REFUSAL OF PLANNING PERMISSION

APPLICATION NO. 2011/0631

Proposal Erection of 1 no. detached bungalow (Outline) (Resubmission)

At Land adjoining 2 Selbourne Close, Barugh Green, Barnsley, S75 1NA

Drawing No. SEA/2SC/001

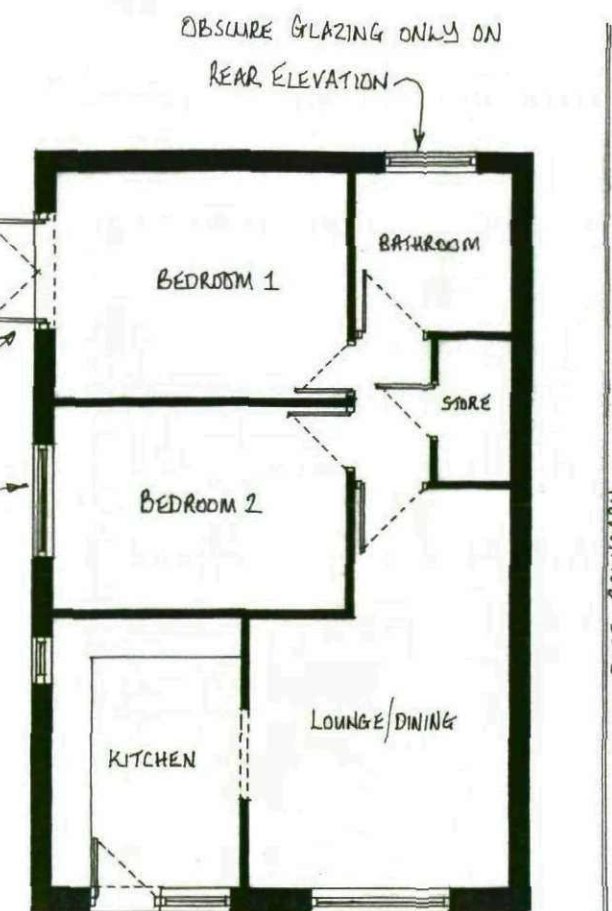
- 2 It is also considered that the plot is of an unacceptable size to accommodate a property which meets design objectives and also achieves an appropriate level of residential amenity. In this regard it is considered that the outlook afforded to the dwelling and its garden would be unacceptably compromised by virtue of the close proximity of the National Grid Pylon. The proposal is therefore considered to be contrary to the advice of H8D 'Infill, Backland & Tandem Residential Development' & SPG3 'Infill Development'

- 3 It is also considered that the present use of the site as garden provides well needed relief from the scale and dominance of the adjacent electricity pylon. The loss of the garden space would reduce the openness of the site and given the close proximity of the pylon it is considered that the bungalow would have a cramped appearance when viewed from the street scene. As such it is considered that the site is of an inadequate size to accommodate a bungalow without having a detrimental impact upon the character of the area. The loss of the area of the existing garden area to development is therefore considered to be contrary to the advice of PPS3 saved UDP Policy H8D 'Infill, Backland & Tandem Residential Development' & SPG3 'Infill Development'
